HERTFORDSHIRE ECOLOGY

LPA reference: 6/2017/0624/MAJ

Proposal: Erection of a 3 storey building for B8 (storage and distribution) (4,878 sq metres) and B1 (office/light industrial) (1,550 sq metres) use, together with 100 car parking spaces, 10 cycle parking spaces, boundary treatment, landscaping, lighting and access.

Location: Plot 5000 Hatfield Business Park Hatfield AL10 9EZ

drawing  
**Proposed Site Layout Plan**

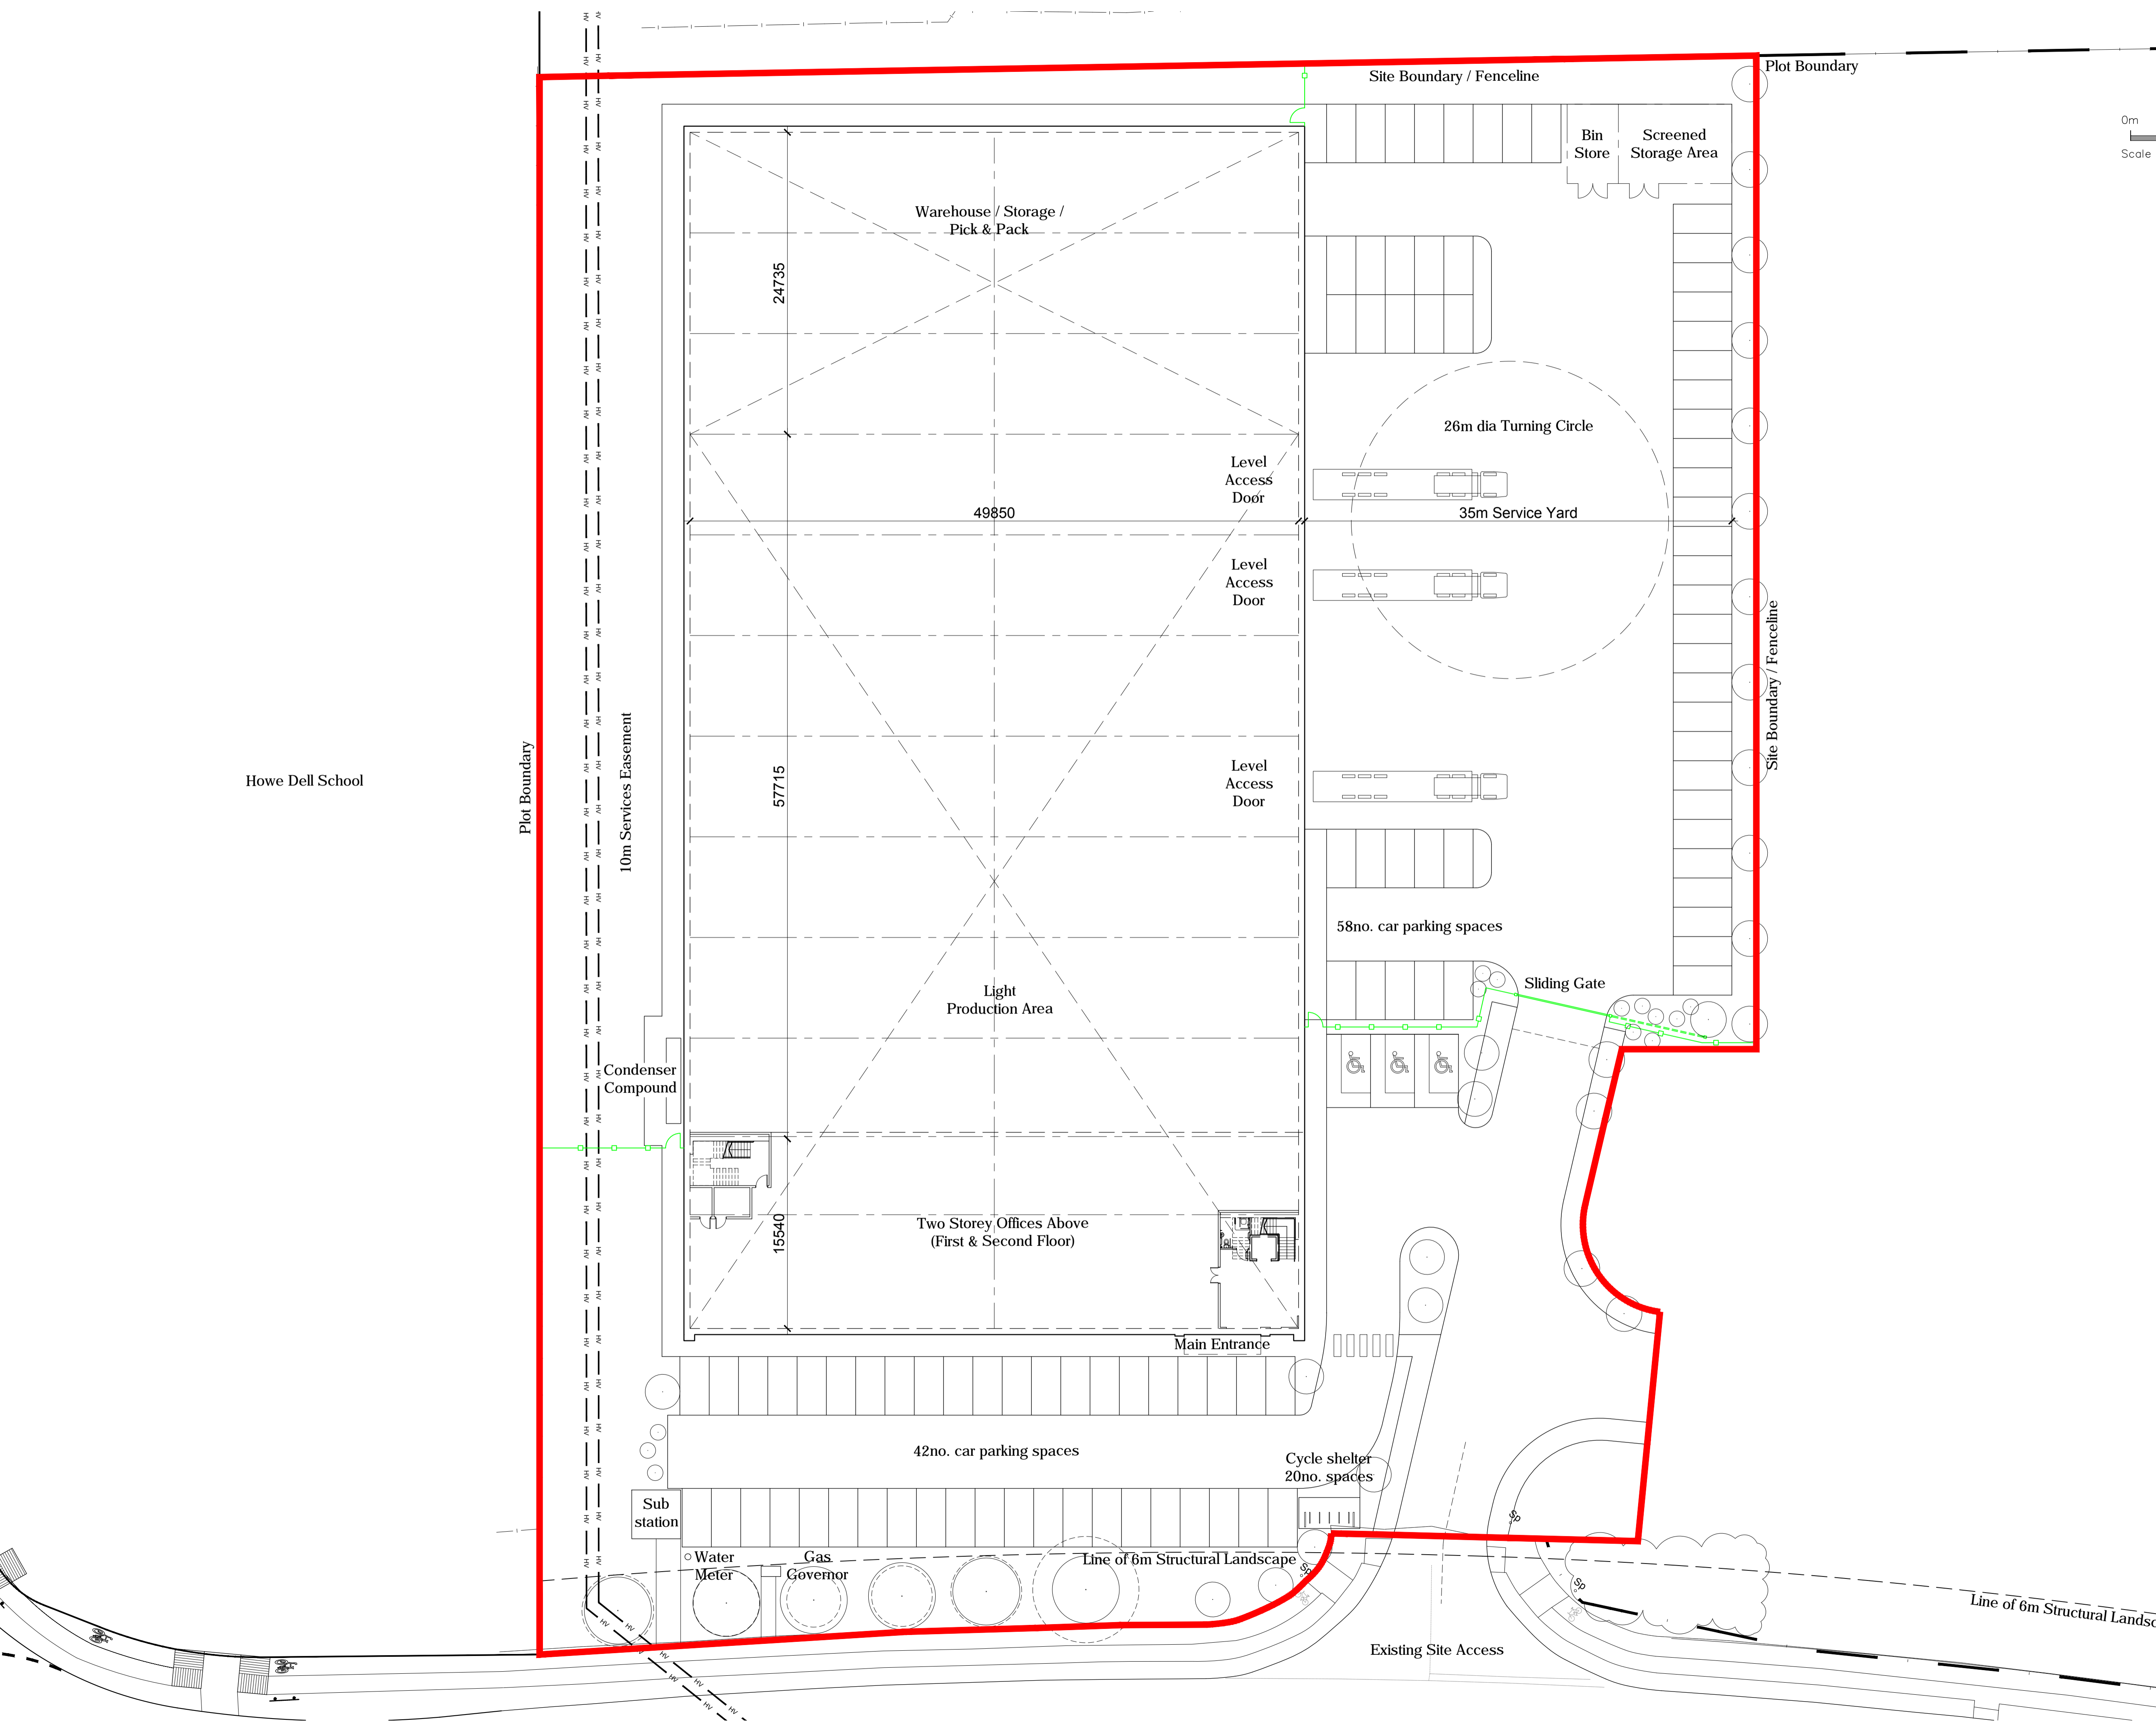
Although it is likely that the biodiversity value of the grassland to be lost is low, the overall biodiversity value of the site will reduce as a result of this application. The applicant has stipulated in their Landscape Design Principles that they wish "To increase the biodiversity of the Site through the provision of areas of planting using native and wildlife friendly species." Presently the design for the eastern, northern, and southern boundaries will be a mixture of

native hedges, ornamental shrubs, and semi mature trees. The western boundary looks to enhance the remaining semi improved grassland with a wildflower seed mix to turn the area into a meadow. This will help to improve the biodiversity value of the site post construction although weather or not it equals that of the original value remains to be seen. The NPPF looks for a no net loss to biodiversity from development and enhancements where necessary. I would advise that the applicant looks carefully at their landscaping scheme to make sure that they have taken every opportunity to enhance biodiversity.
